**Conditions of development consent for the Sydney Metro Martin Place Station Precinct
SSD 9270 – North Site**

Condition B5, B6 and B7 discharge request #5 – Design excellence and design integrity review

1.0 Design changes – endorsement prior to Construction Certificate

Level 15 Plan

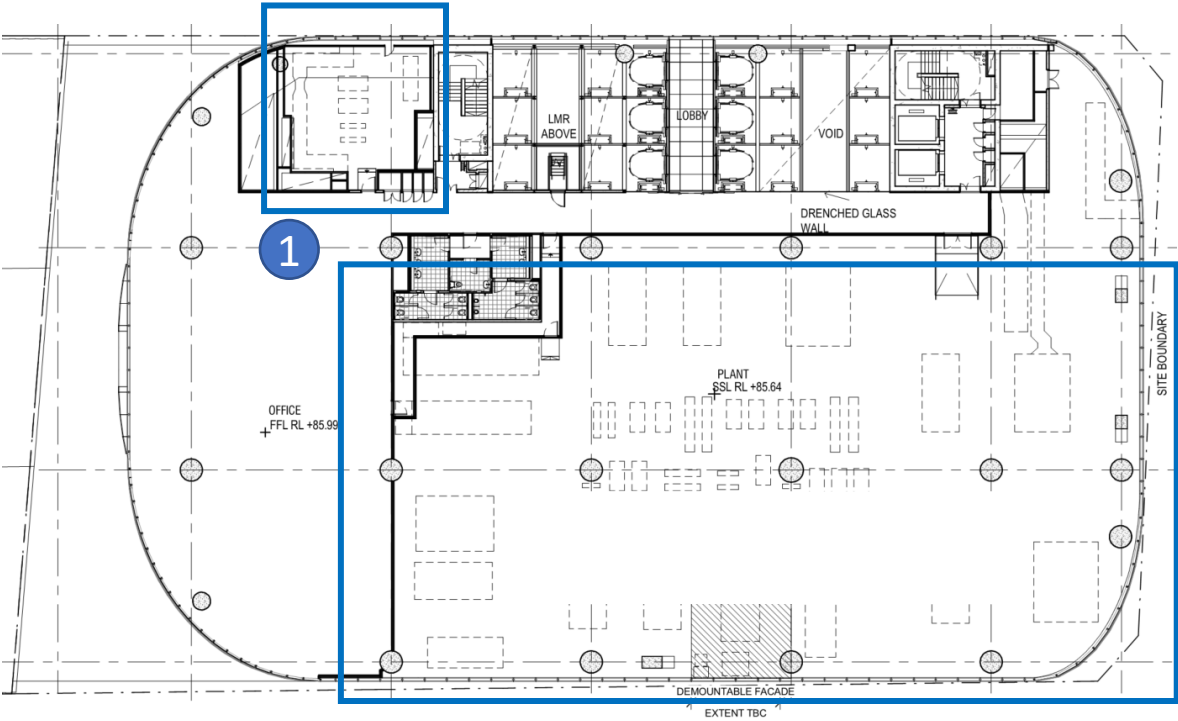
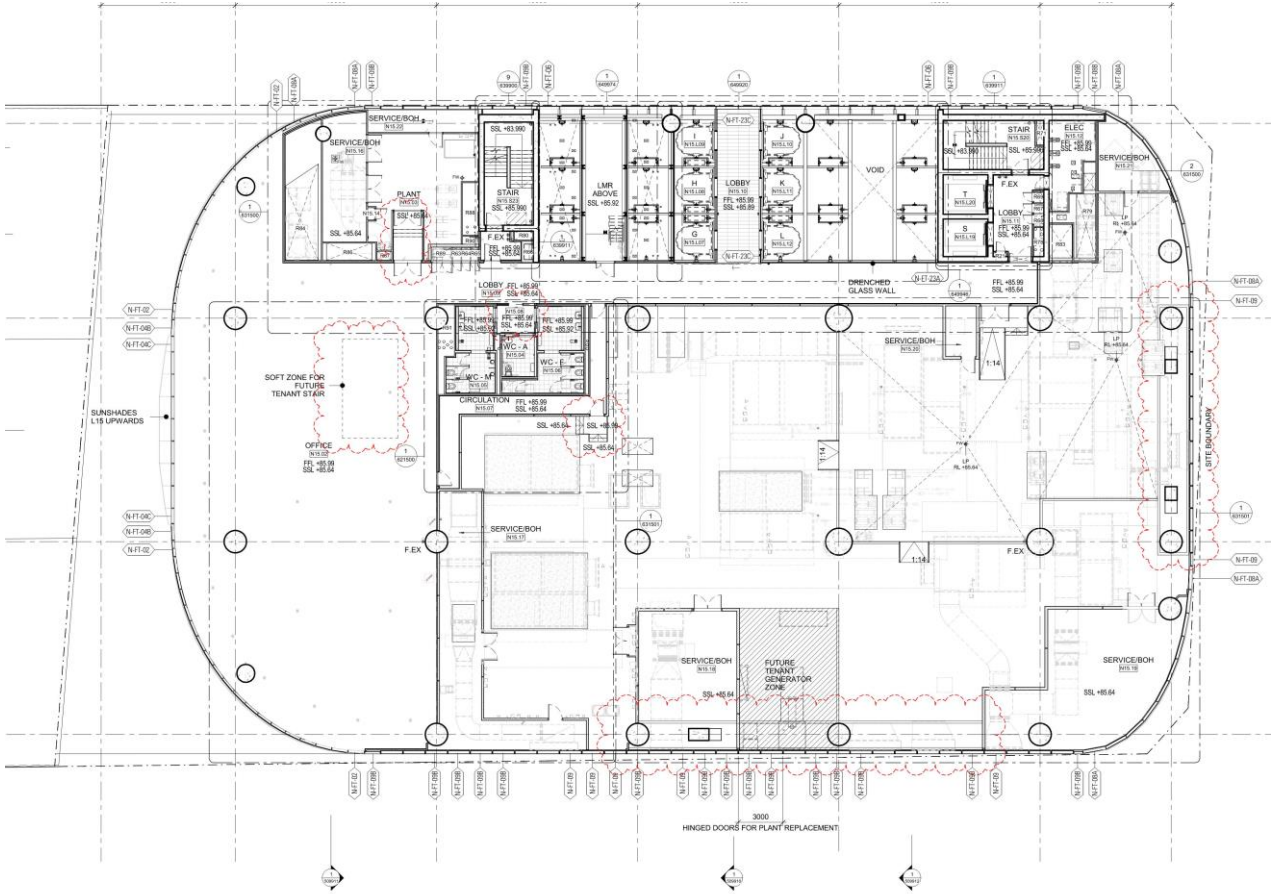
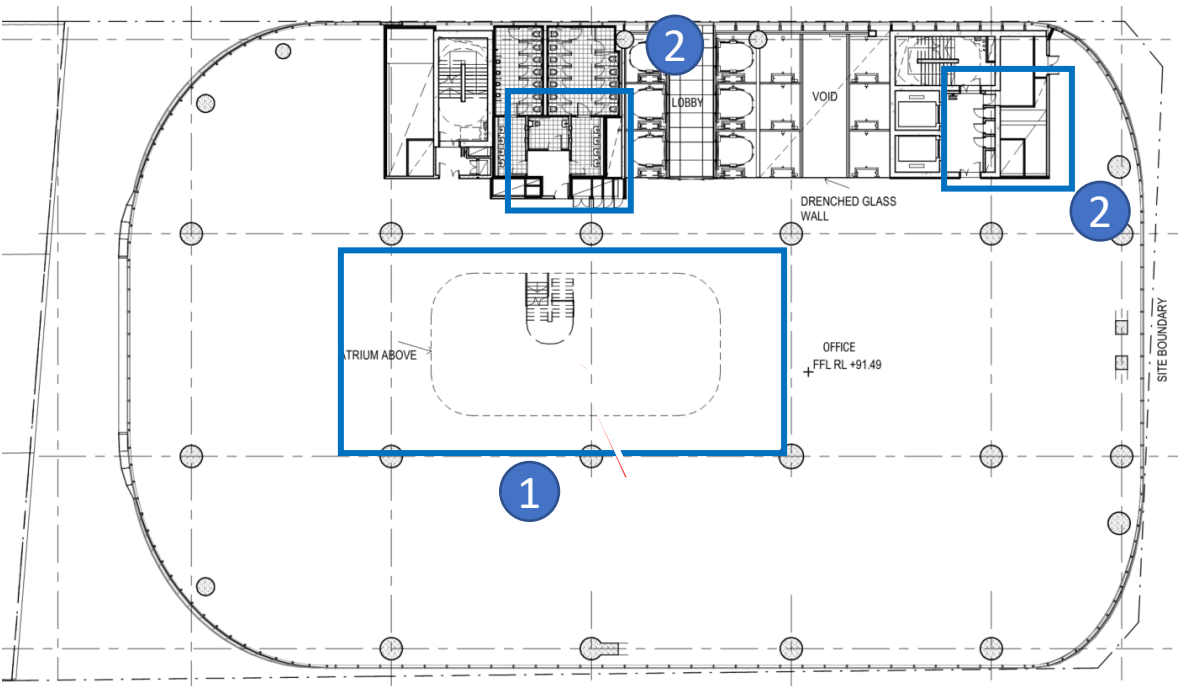
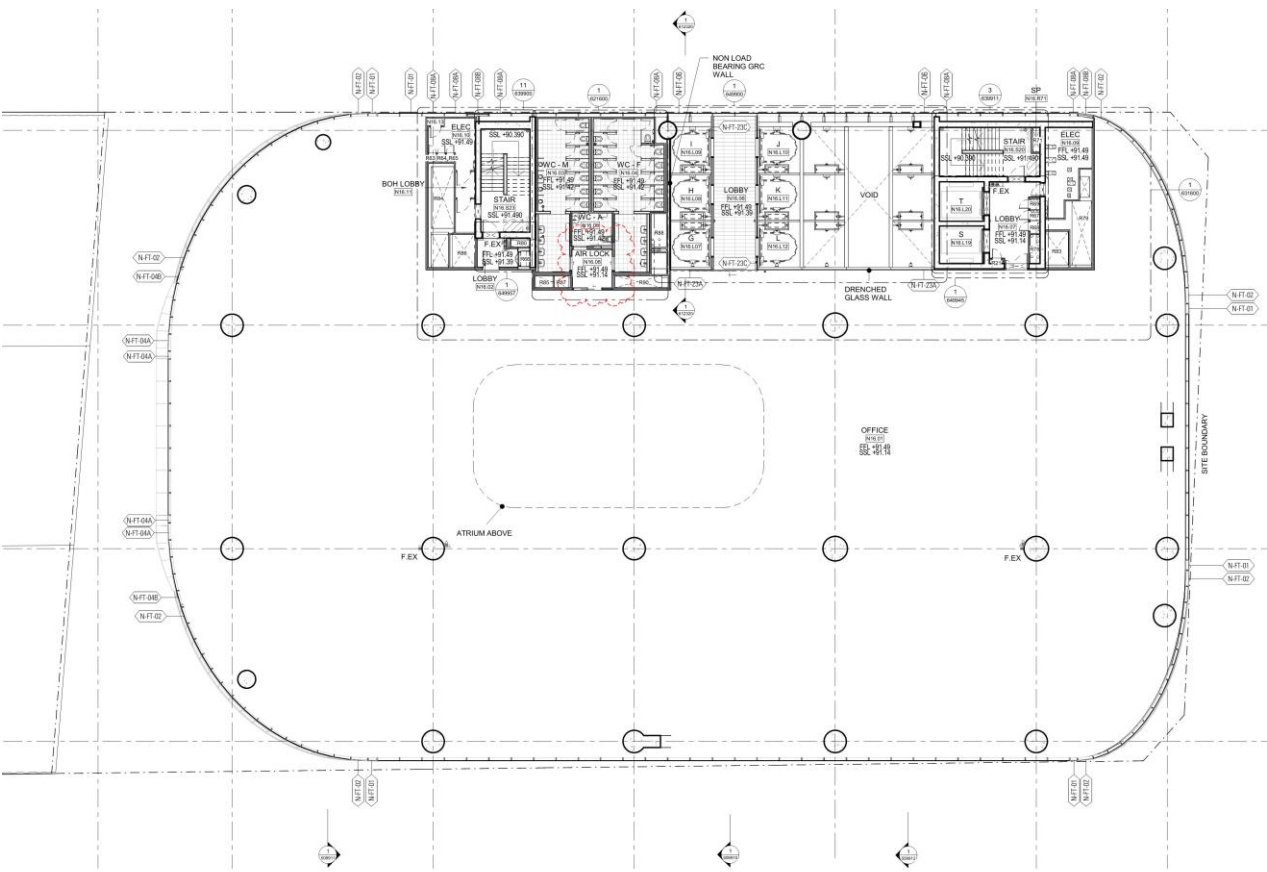
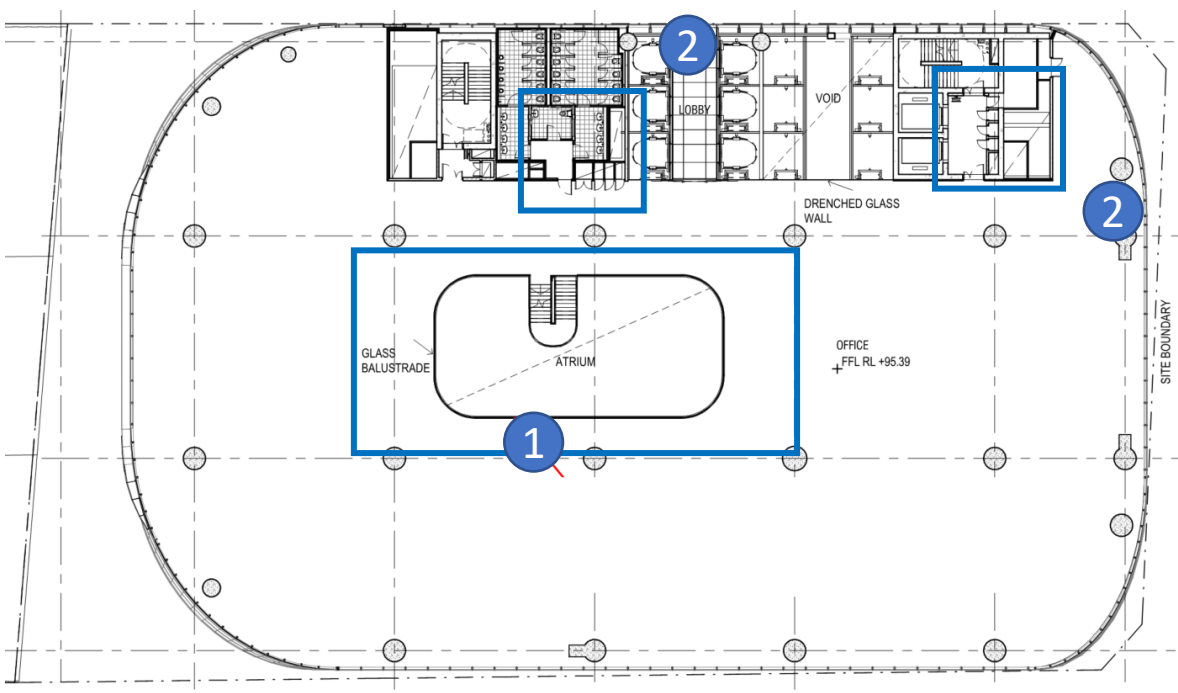
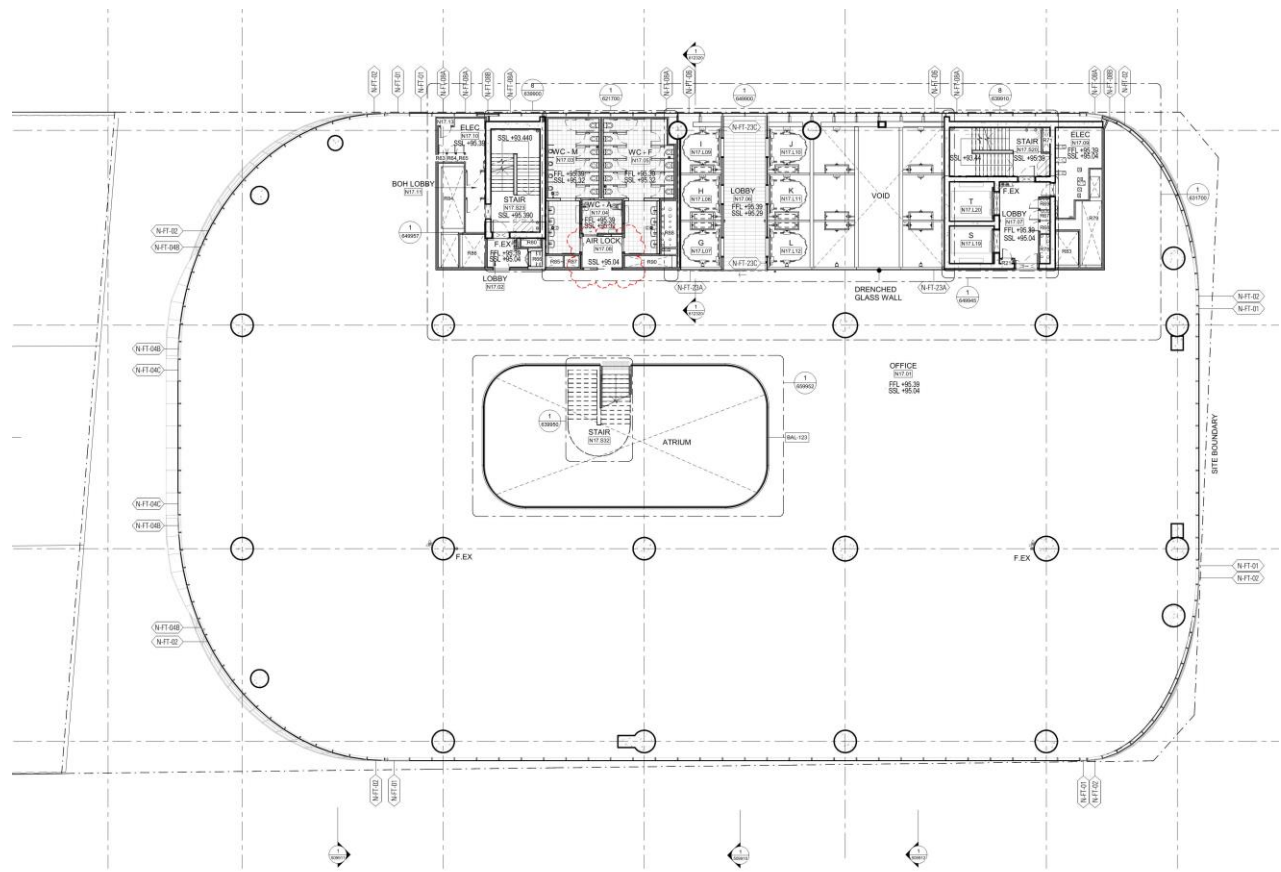
Levels 16-27		
Slide 12-23	Revised atrium and inter tenancy stair design and positioning.	OSD DRP review is not considered necessary on the basis the proposed changes are very minor, wholly internal and will not result in any changes to the exterior of the building.
Level 28		
Slide 24	Revised plant configuration.	OSD DRP review is not considered necessary on the basis the proposed changes are very minor, wholly internal and will not result in any changes to the exterior of the building.
Levels 29-33		
Slide 25-29	Revised back of house configuration.	OSD DRP review is not considered necessary on the basis the proposed changes are very minor, wholly internal and will not result in any changes to the exterior of the building.
	Columns deleted.	
Level 34		
Slide 30	Revised back of house configuration.	OSD DRP review is not considered necessary on the basis the proposed changes are very minor, wholly internal and will not result in any changes to the exterior of the building.

Lower Roof Plan

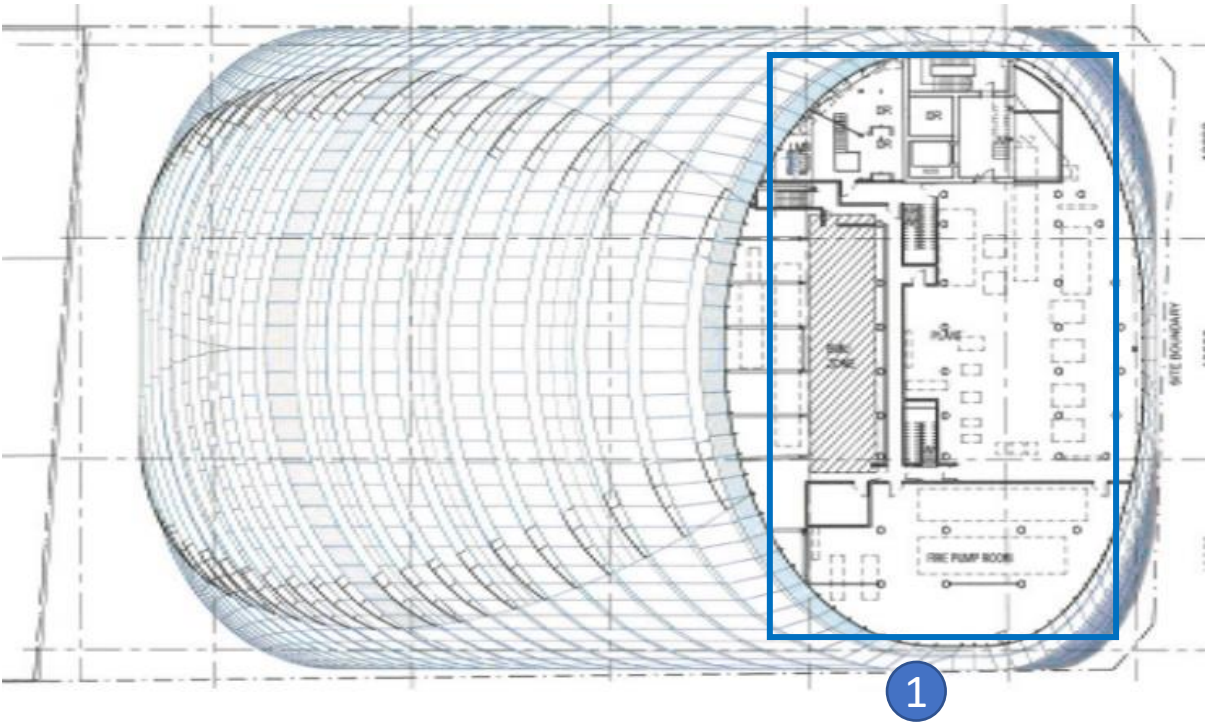
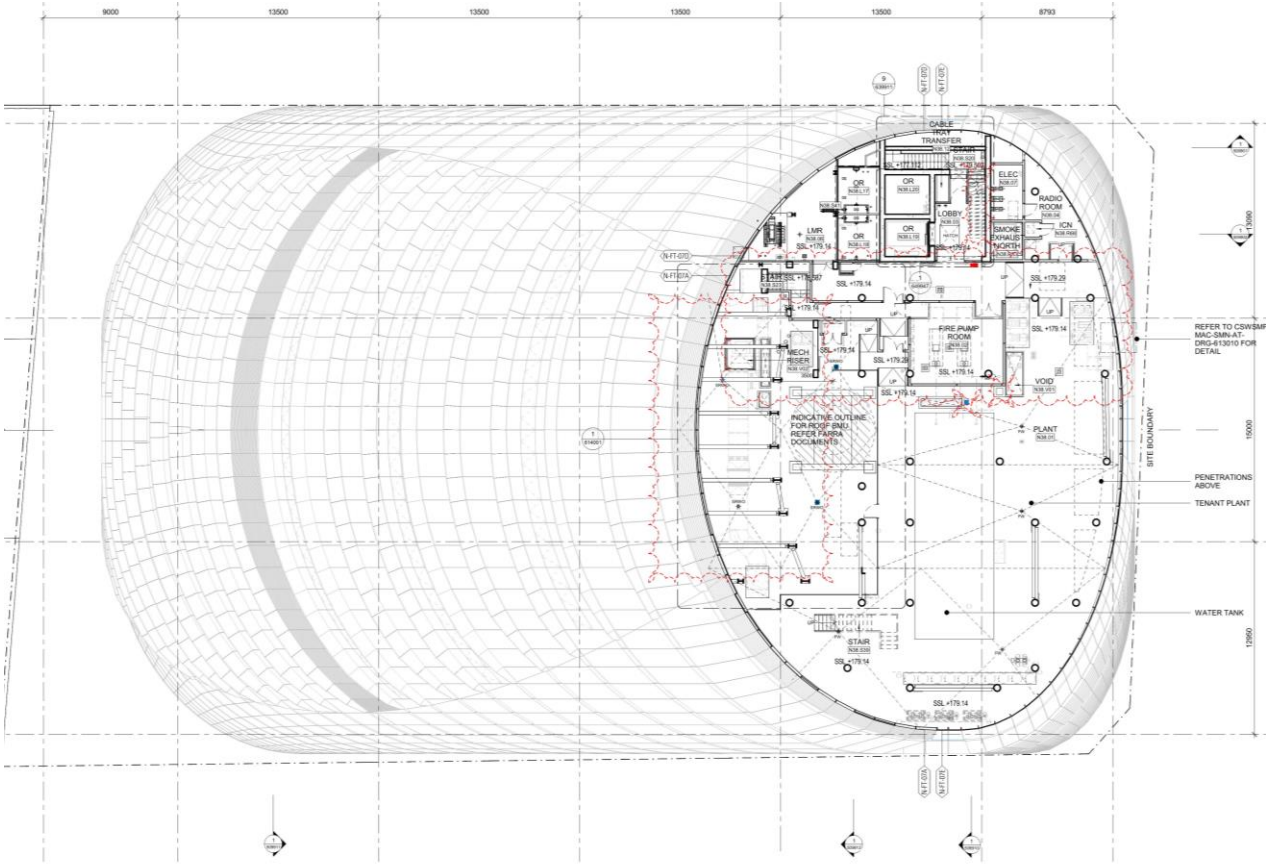
Columns revised.	
Level 35-37		
Slide 31-33	Revised back of house configuration.	OSD DRP review is not considered necessary on the basis the proposed changes are very minor, wholly internal and will not result in any changes to the exterior of the building.
Lower Roof Plan		
Slide 34	Revised plant configuration.	OSD DRP review is not considered necessary on the basis the proposed changes are very minor, wholly internal and will not result in any changes to the exterior of the building.
Upper Roof Plan		
Slide 35	Revised plant configuration.	OSD DRP review is not considered necessary on the basis the proposed changes are very minor, are not visible from the public domain, and do not materially change what was approved through SSD 9270.
	Building maintenance unit hatch reduced in size.	
East elevation		
Slide 36-37	Additional generator flues.	OSD DRP review is not considered necessary on the basis the proposed changes are very minor, are not visible from the public domain, and do not materially change what was approved through SSD 9270. The changes are typical of design development.

East Elevation

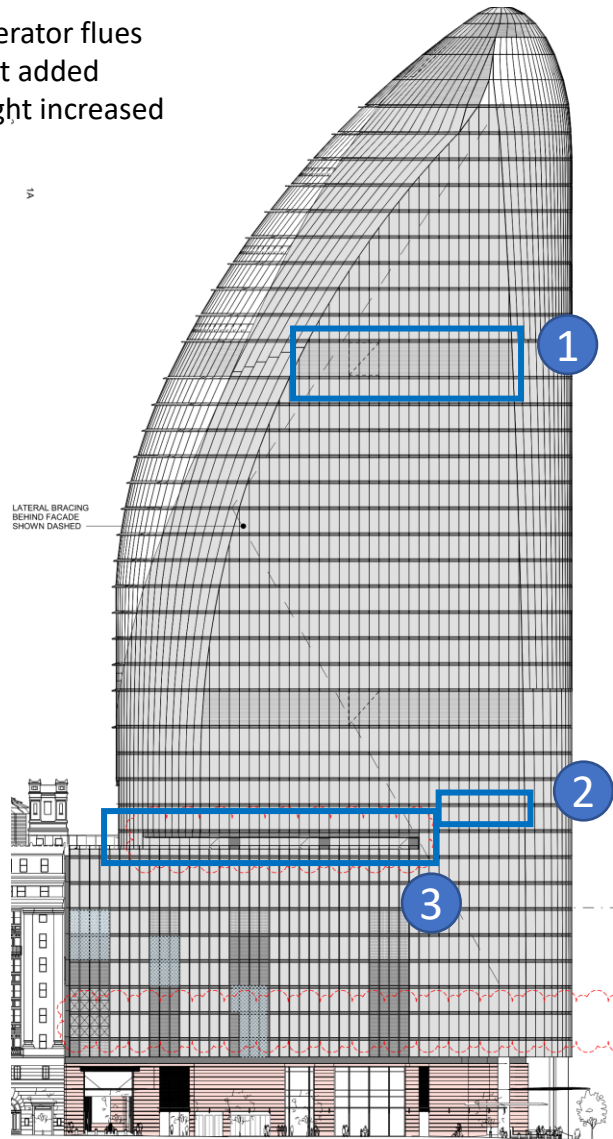
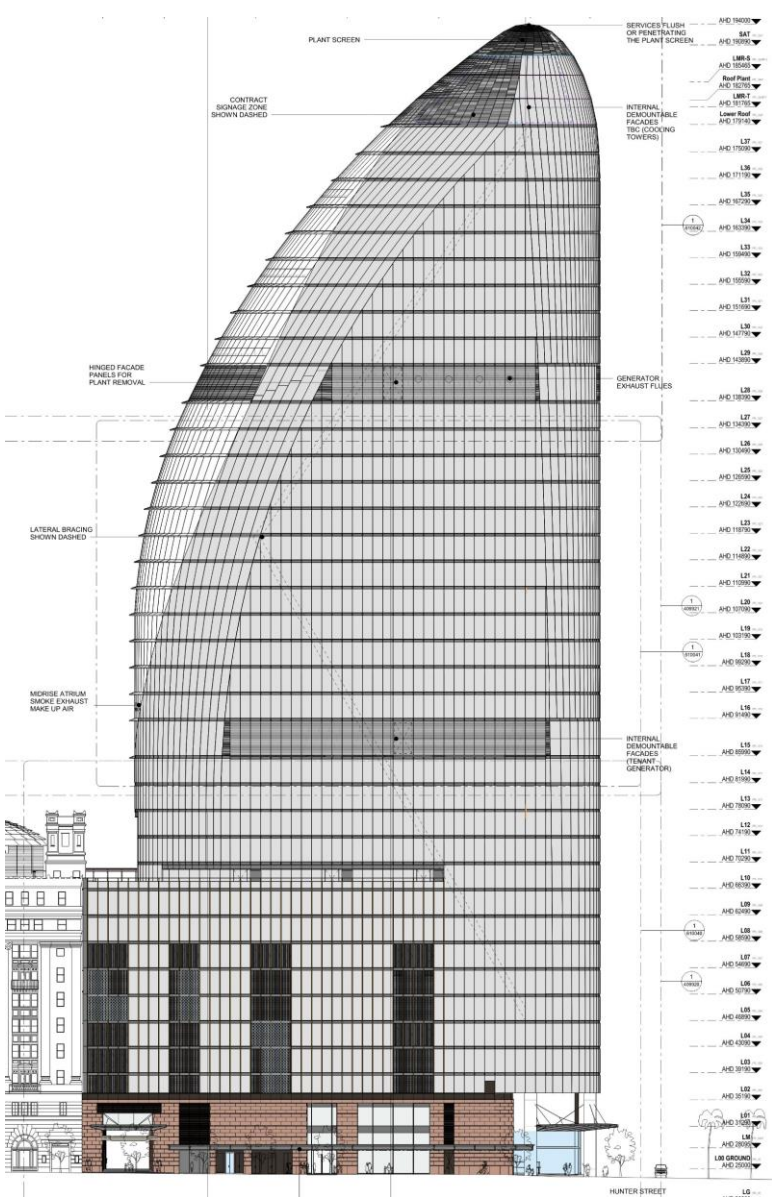
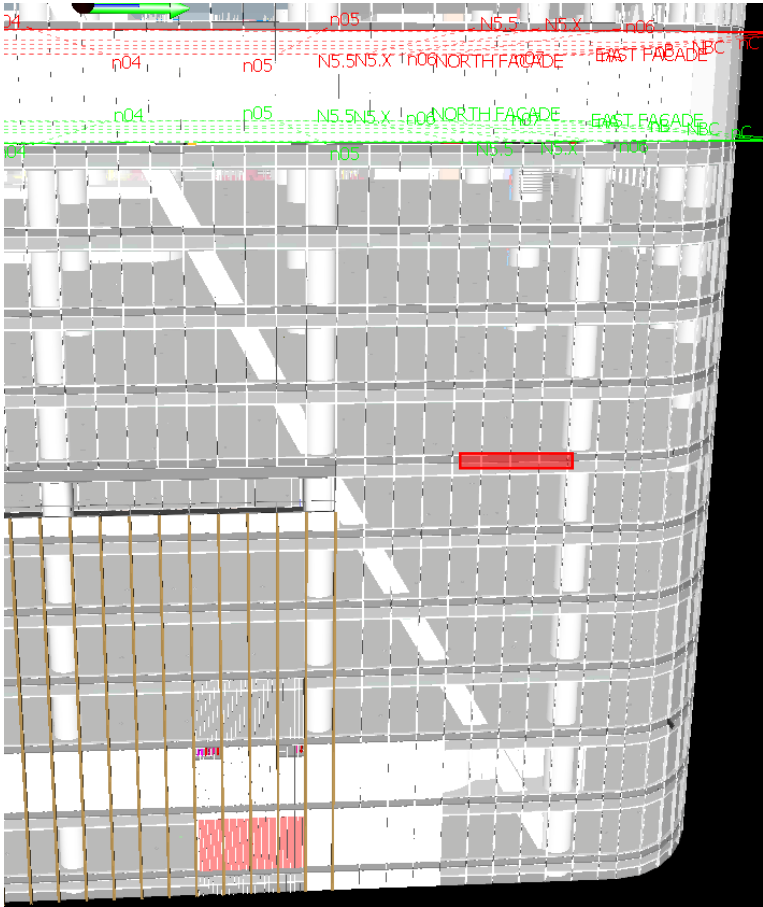
Kitchen exhaust added.
